**From:** Bob Neville  
**Sent:** 10 March 2021 12:27  
**To:** DC Support  
**Subject:** FW: 20/03660/REM - Stone Pits, Hempton Road, Deddington  
**Attachments:** Landscape.pdf; LANDSCAPING - General Guidance.doc

**From:** Tim Screen <Tim.Screen@Cherwell-DC.gov.uk>  
**Sent:** 23 February 2021 15:05  
**To:** Bob Neville <Bob.Neville@cherwell-dc.gov.uk>  
**Subject:** 20/03660/REM - Stone Pits, Hempton Road, Deddington

REV	DESCRIPTION	APP.	DATE
 Clewsla Landscape Architecture Ltd, 17 Hempton Road, Bury, Cheshire, CH16 9RE 01293700264 www.clewsla.co.uk			
Hempton Road site DEDDINGTON LANDSCAPE MASTERPLAN HARD AND SOFT LANDSCAPE			
DWG. NO: 20_218_0010			
SCALE:	1:2000A0	DATE:	DEC 2020
STATUS:	PLANNING	DRAWN:	CC

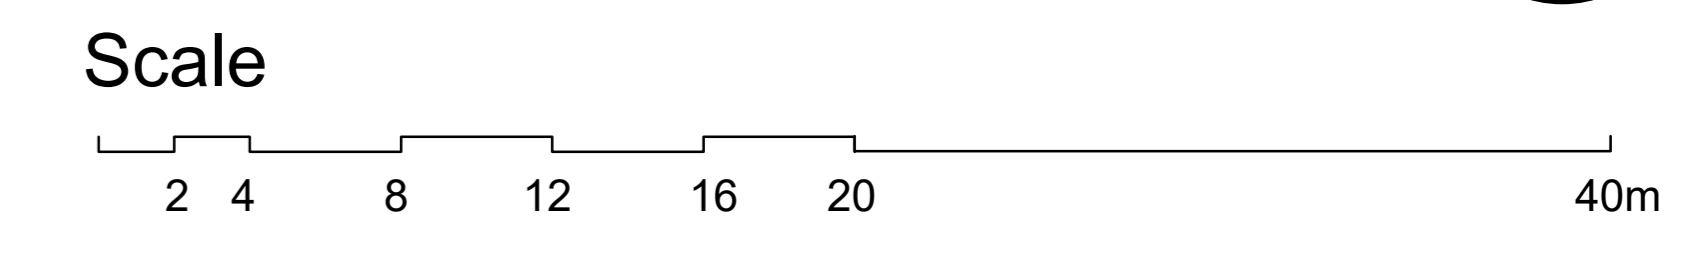
Improved visual mitigation of dwellings as one approaches on Hempton Rd from the west is necessary – refer to enclosed landscape proposals for guidance on the position of trees to the western boundary. Plant 3no Acer campestre, 1no Prunus avium (well away from hard surfaces and utilities) and 3 no Sorbus aucuparia (away from hard surfaces as berries cause unsightly mess). Allow for a ‘framed view’ experience from windows

Replace the larger Carpinus (hornbeam) with the smaller Sorbus aucuparia on the northern boundary, and ensure the trees are planted in a more naturalist arrangement, not equidistant as shown, and allowing for a ‘framed view’ experience directly from windows. Delete the Cb near the species rich hedgerow because it too close the access path and may cause the path to lift and crack with its roots.

For the southern boundary fronting the road the trees are planted in a more naturalist arrangement, not equidistant as shown, and allowing for a ‘framed view’ experience directly from windows.

Delete the 3 Cb from the R/H side of the highway access to allow for maintenance access between hornbeam hedge and attenuation pond

Add 4 Alnus glutinosa at the southern edges to the balancing pond – refer to landscape proposals. Obviously keep well away from outlet and inlets, etc. because of root disturbance.

Once the ownership and design layout issues have been addressed for the green ‘courtyard’ in the centre, all proposed trees are to be deleted if the current layout remains. The Cb trees will cast dense shade and restrict light to windows and Sa trees are too close the edge of the paved path, potentially causing it to lift and pavements to separate.

The wildflower corridor to the northern boundary with the backdrop of the formal Cb hedge with native trees requires areas of native thicket planting to provide a more naturalistic character than indicated. Which party will own and maintain this corridor?

Proposed shrubs *Amelanchier lamarckii*, *Mahonia x media* 'Winter Sun', and *Viburnum x burkwoodii* These shrubs can be too large in narrow borders adjacent to windows. They can grow over paths and parking bays and have to be unsympathetically pruned for facilitate access. Smaller shrubs that act as ground cover should be used at the front of beds and borders. Shrubs such as *Euonymus fortunei* 'Emerald and Gold', *Lonicera* 'Maygreen', *Sarcococca humilis* and herbaceous perennials *Bergenia cordifolia* and *Pachysandra* 'Green Carpet' Planting densities must be shown.
